An
Coimisiún
Pleanála

**Memorandum
ABP-322958-25**

To: Stephen Rhys Thomas
From: Colm McLoughlin
Re: Further Information
Date: 5th January 2026

I recommend that further information should be sought from the applicant for this application under section 37(F)(1) of the Planning and Development Act 2000, as amended, requesting the following:

DRAWING No: 120278-501

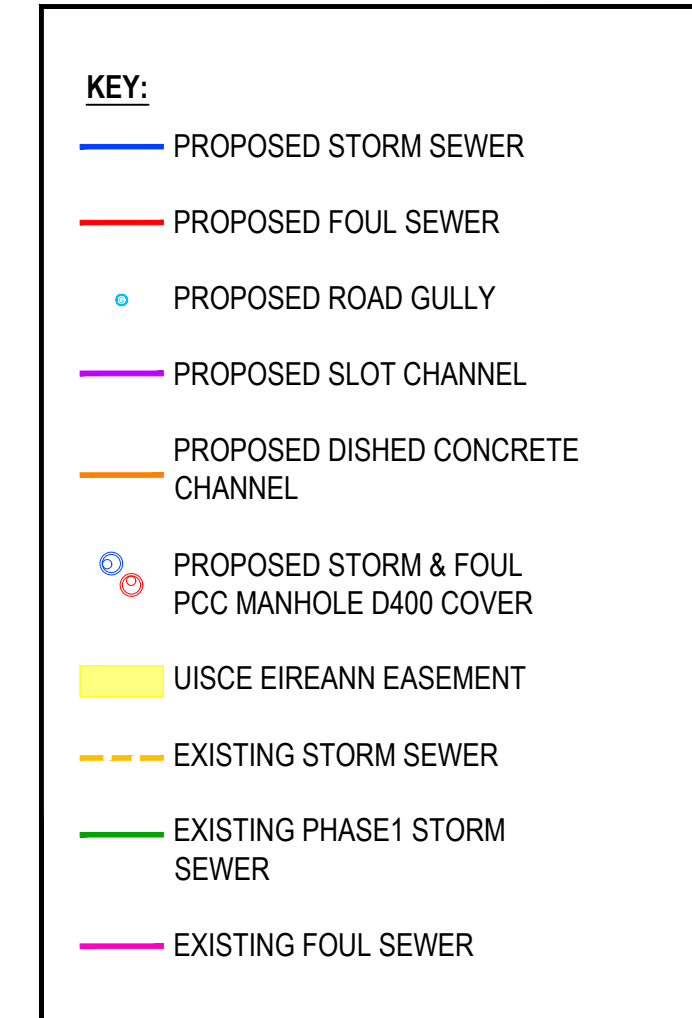
- 1) The application Drainage Report refers to shallow channels as draining the western side of the site and the immediate areas to the north and south. This Drainage Report also states that the application site is on occasion subject to flooding and that despite sizing the proposed surface water drainage infrastructure to accommodate all storm durations and intensities up to a 1:30 year storm (plus a 20% climate change factor), during exceptional events in excess of this water levels may overtop the discharge control (hydrobrake) and result in short-term uncontrolled flows towards the culvert draining west under Southern Station Road, towards an area that is noted to be prone to flooding under the Shannon Catchment Flood Risk Assessment and Management Study. The Westmeath County Development Plan 2021-2027, the operative statutory plan for this area, includes policy objective CPO 10.106 requiring flood risk assessments to be carried out for any development proposals within 200m of a watercourse and at risk of flooding. The applicant is requested to submit a Site Specific Flood Risk Assessment following the approach set out in 'The Planning System and Flood Risk Management Guidelines for Planning Authorities' (2009), including the Technical Appendices.

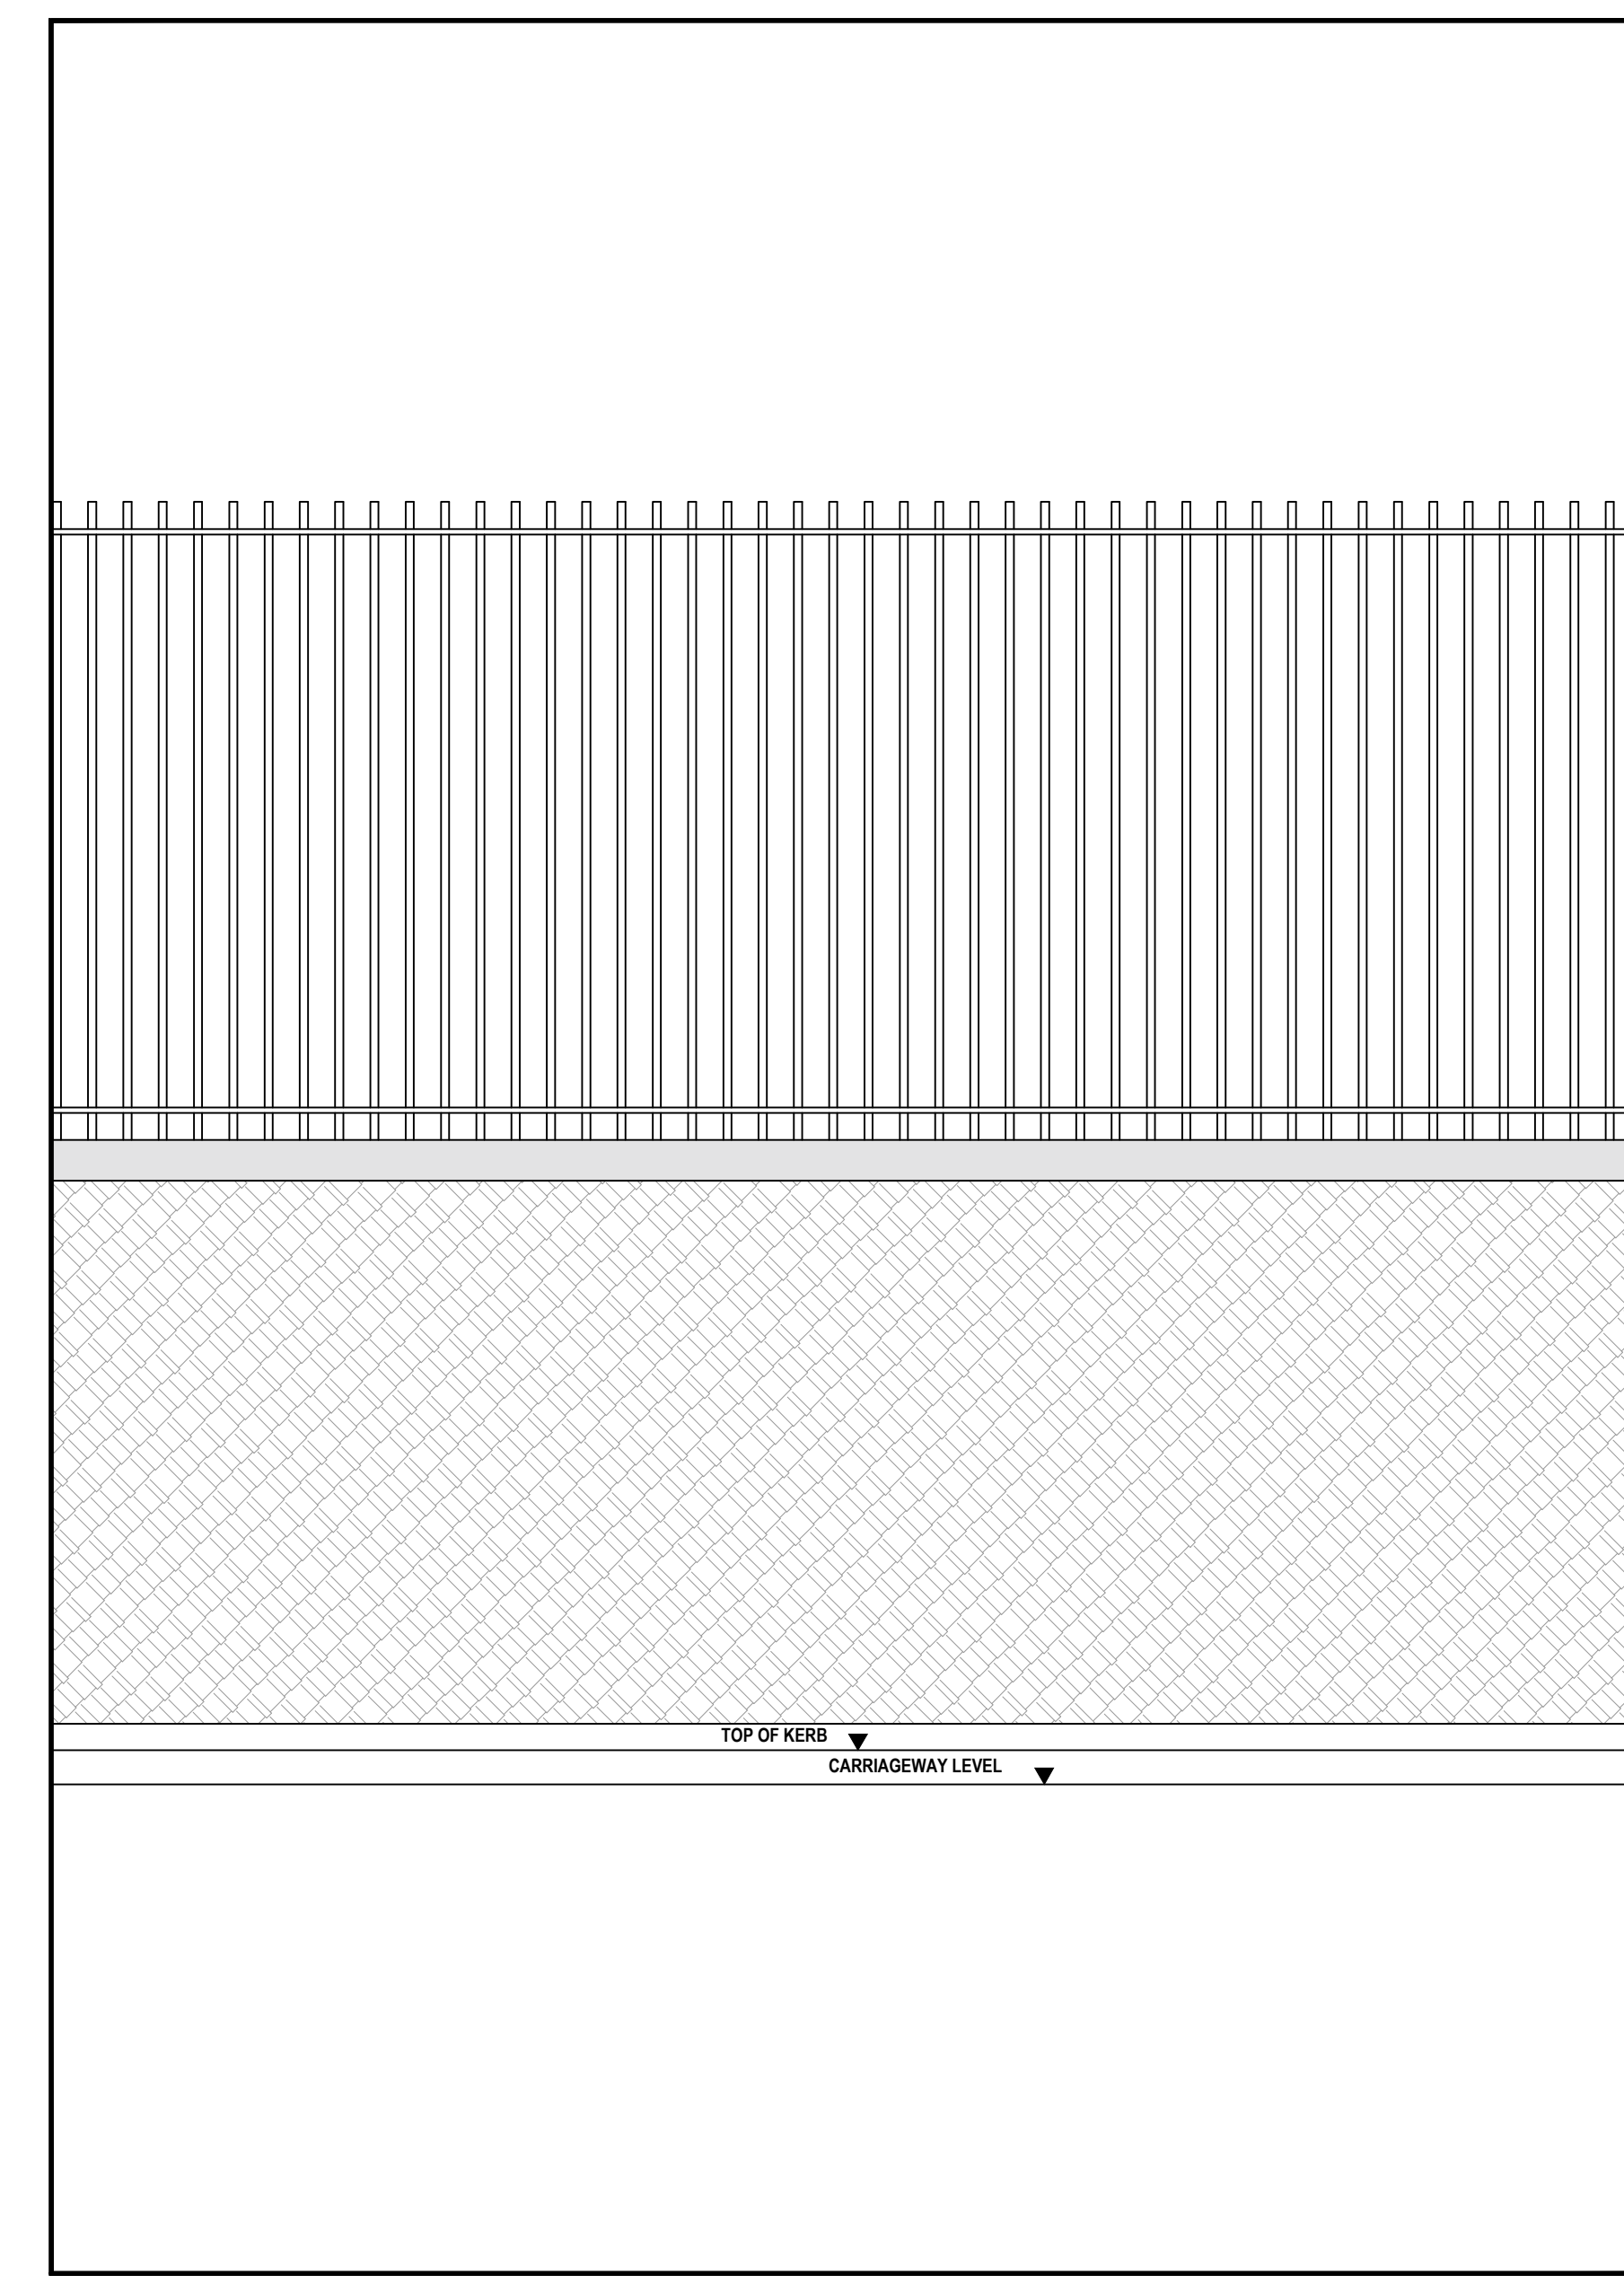
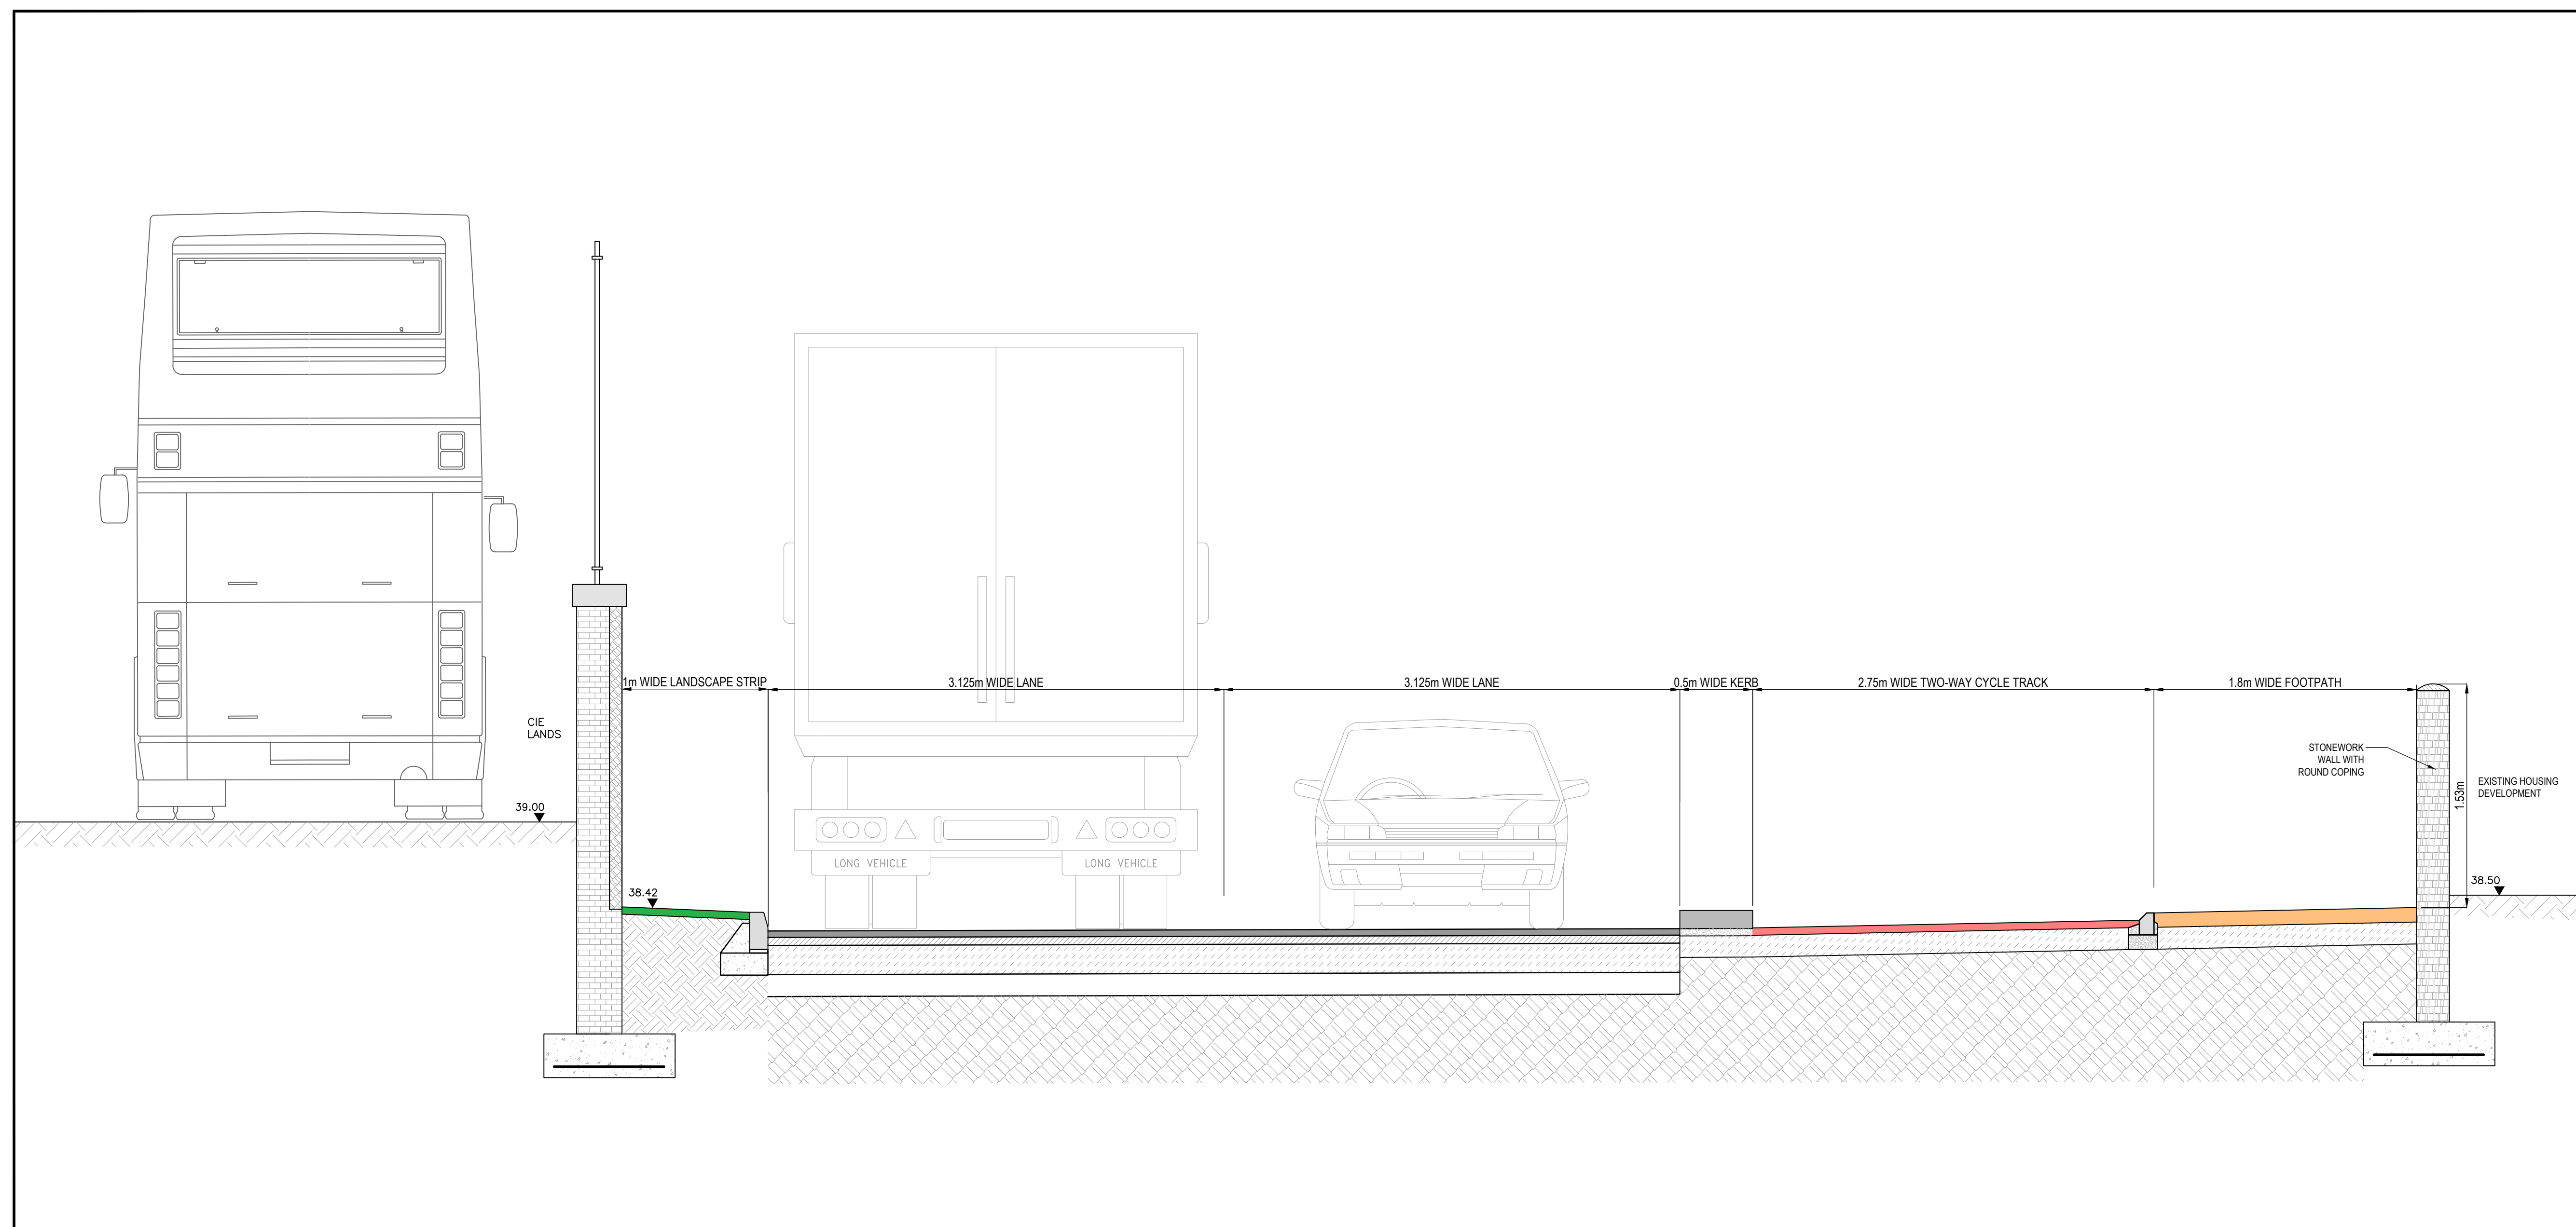
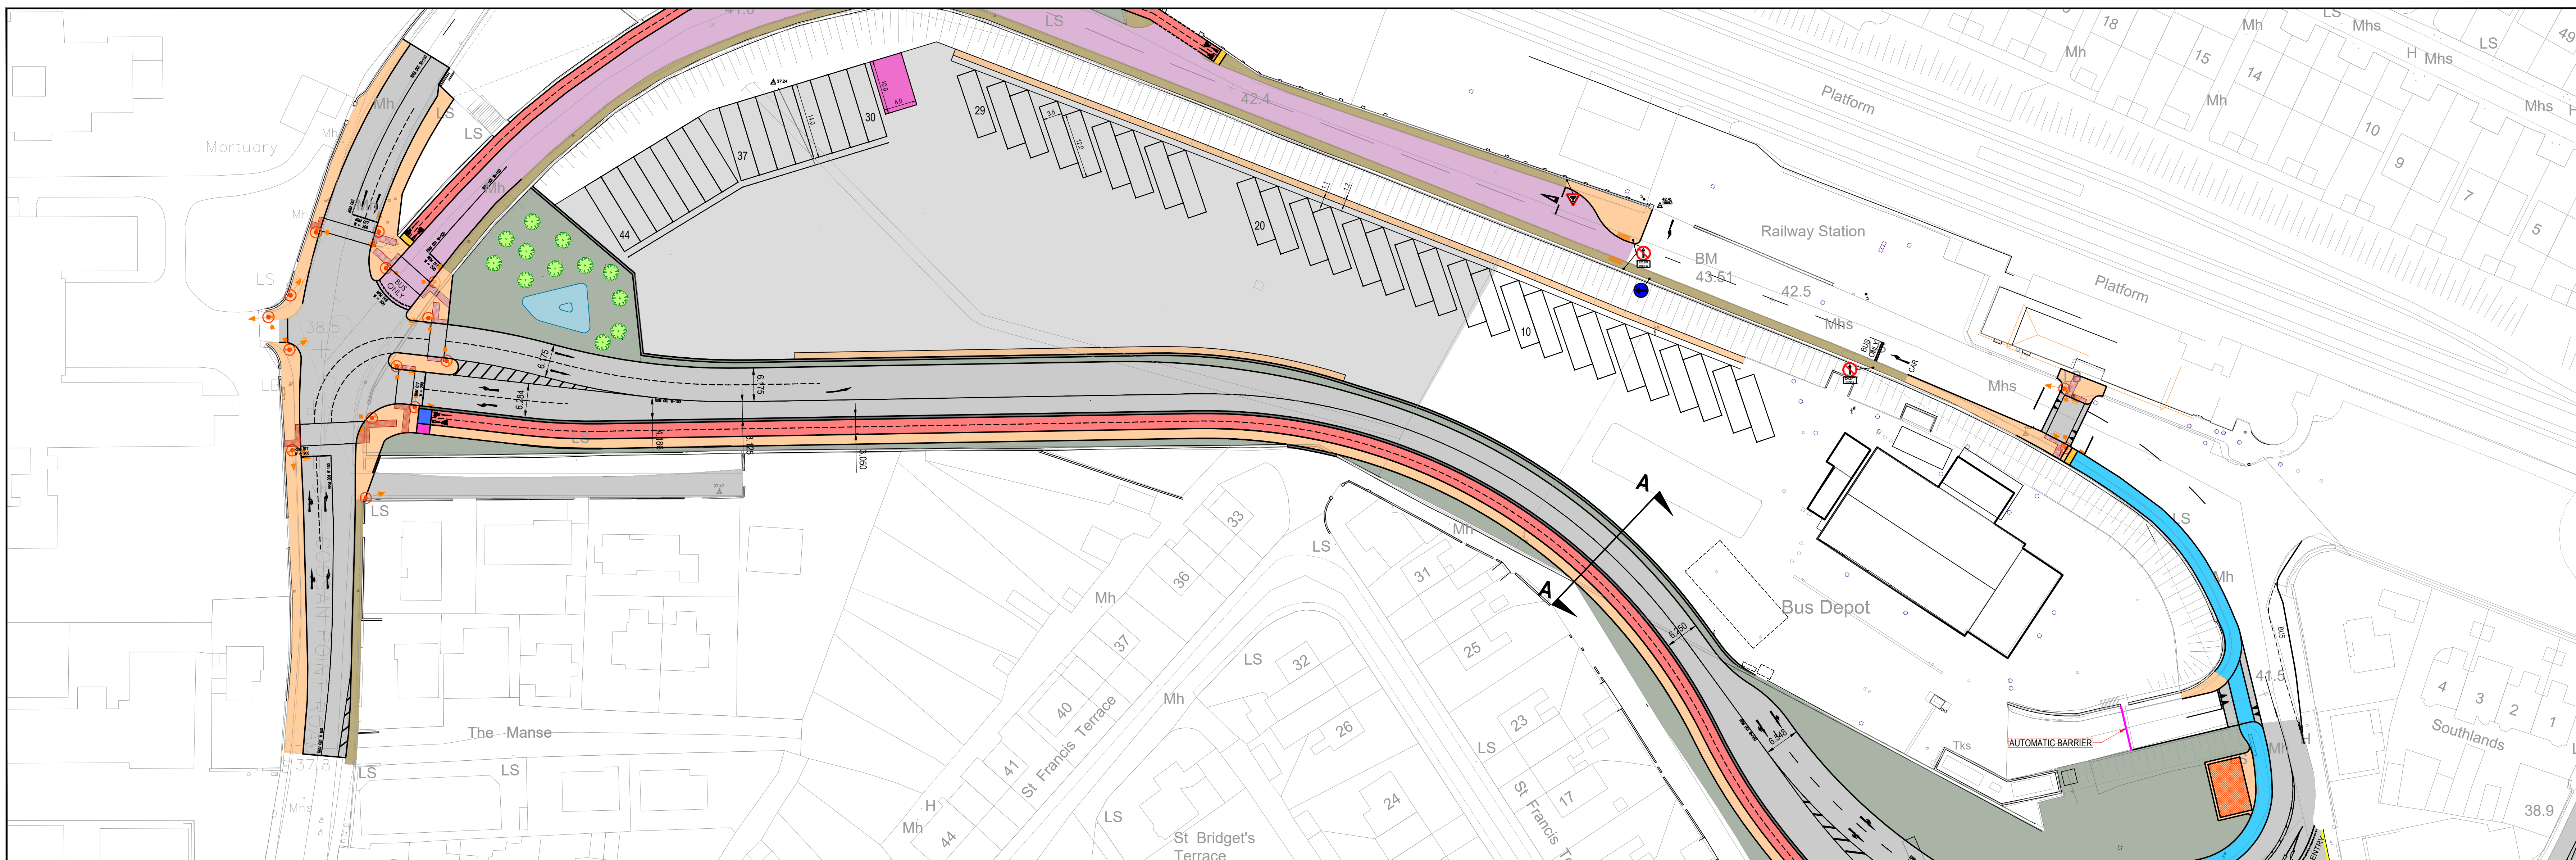
- 4) The applicant is requested to provide cross-section drawings to a stated metric scale, illustrating the context for the proposed link road and housing along The Manse and St. Francis' Terrace.
- 5) The applicant is requested to provide floor plan, elevation and section drawings to a stated metric scale for the tyre store building that is proposed to be relocated within the bus depot.
- 6) The applicant refers to calculations for the foul drainage proposals as being contained in appendix E to their Drainage Report. The applicant is requested to submit this 'appendix E', as it appears to have been omitted from the planning application.
